Application no: H13/0363/95

Amendment: Revised roof materials - from Sandtoft Tile 'Bracken' to
Sandtoft Slate 'Dark Grey'

TOWN AND COUNTRY PLANNING ACT 1990
NOTICE OF ACCEPTANCE OF AMENDMENT

North - East Elevation

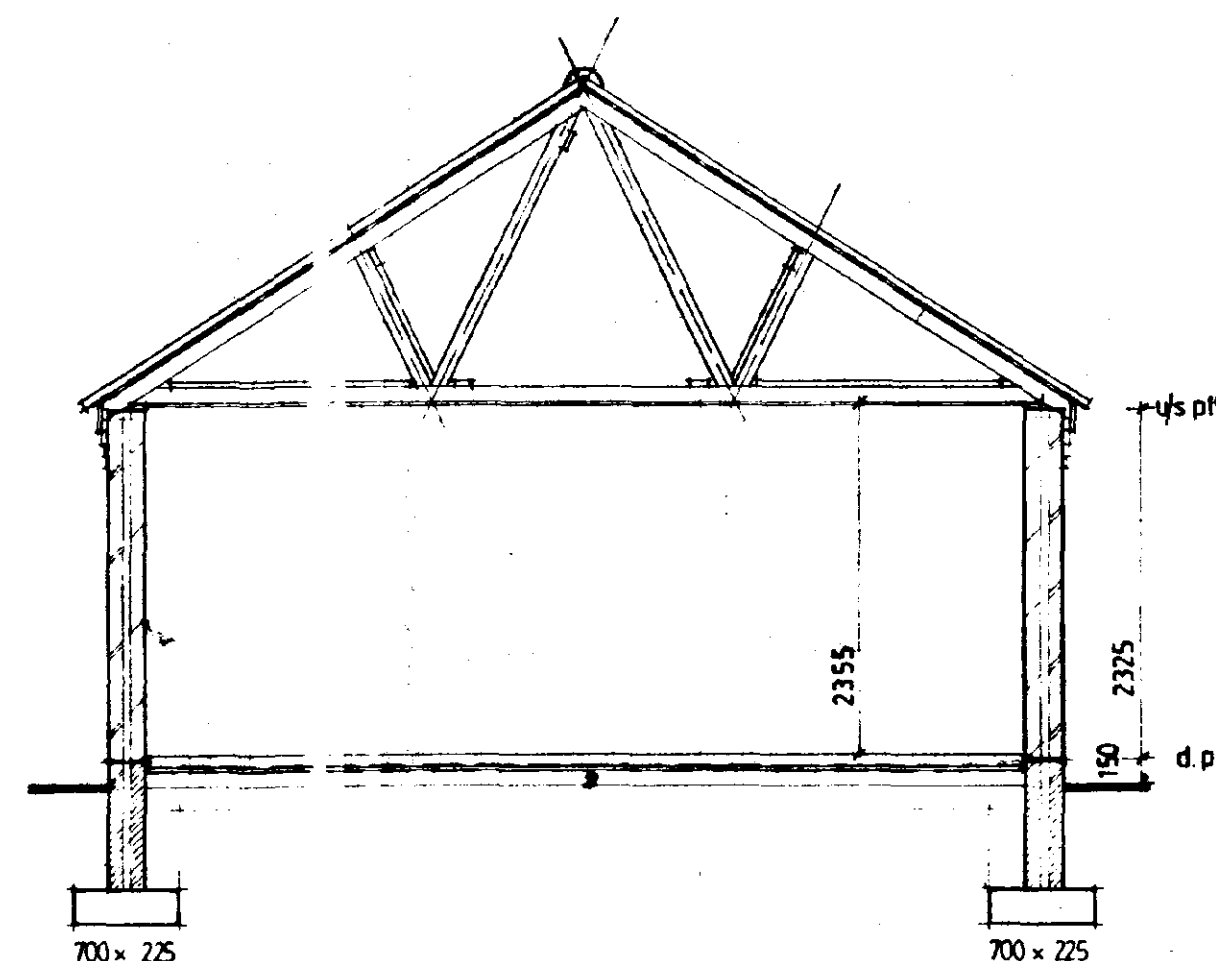
I refer to my telephone conversation with Sue Myles today when I advised her that the roof tile, which were approved in December 99 have been discontinued, I would like to submit the following tile as a replacement.

Sandtoft Calderdale Slate in Dark Grey.

If possible we would like the ridge tiles to be Terracotta red, otherwise to be Dark Grey the same as the tiles.
